Your Ref: M/64/19/PL

I am writing to express concerns over the proposed planning application for the erection of a 2 bedroom bungalow in the grounds of 27 Shrubbs Drive.

GROUND FLOOR PLAN
[1:50]

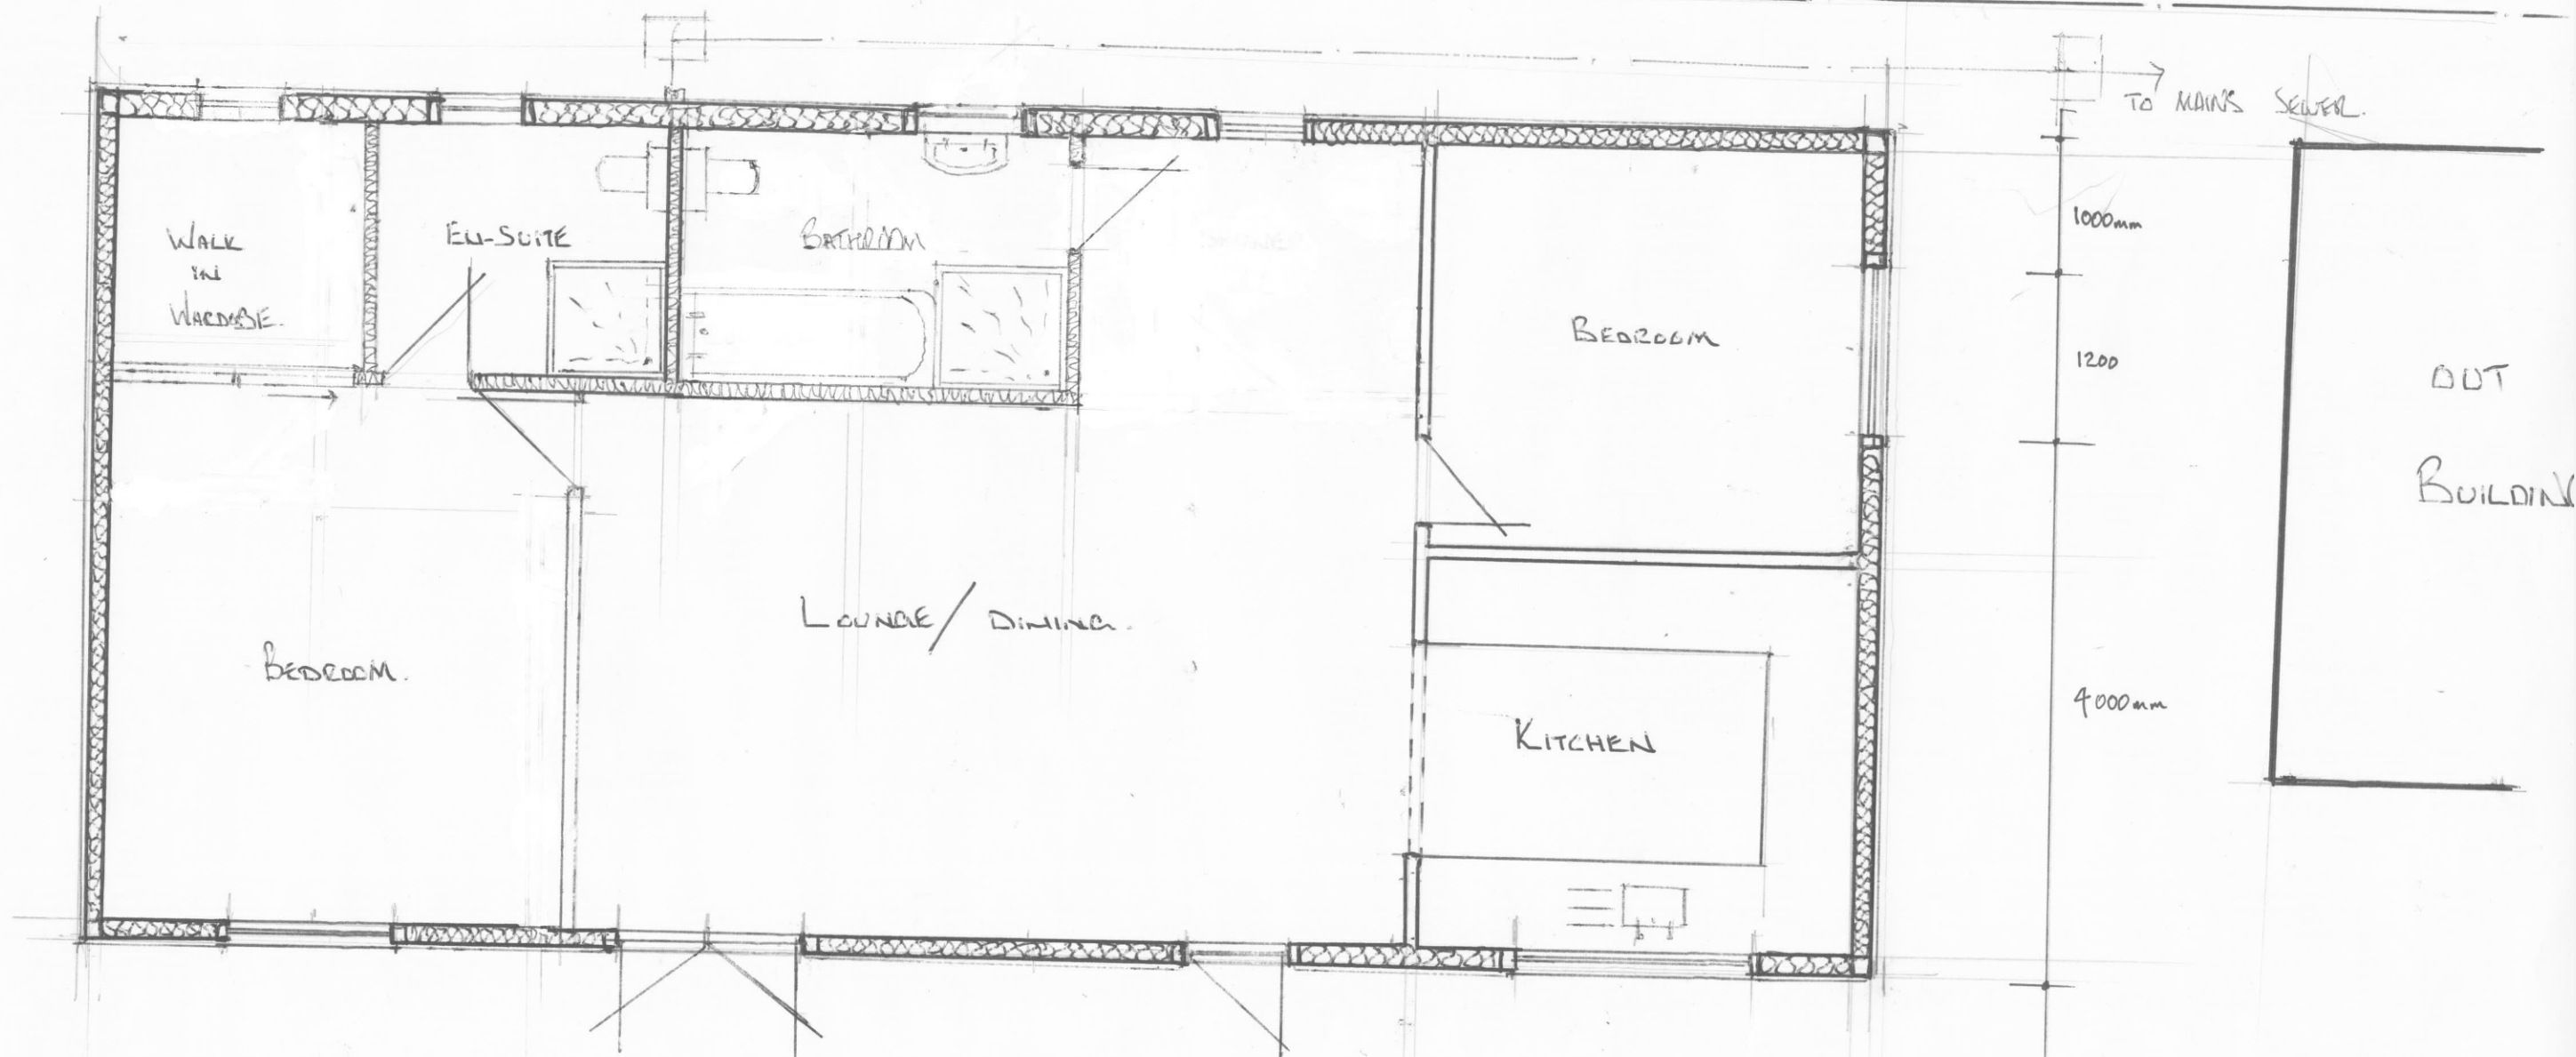
- 2 Section 9 of the application doesn't detail the type, colour and name of materials.
- 3 Section 10: makes no comment as to parking provision for any additional vehicles, parking is already an issue with the beauty studio customers parking in the road making access to adjoining property driveways difficult. The proposed new bungalow will clearly increase parking requirements, therefore this issue should be addressed.
- 4 Section 14: Existing use states Domestic, I do not believe this to be a correct statement and should be investigated further.
- 5 Section 17: As you have already commented section not completed.
- 6 The submitted floor and elevation plans are not accurate and no details of the height of the building
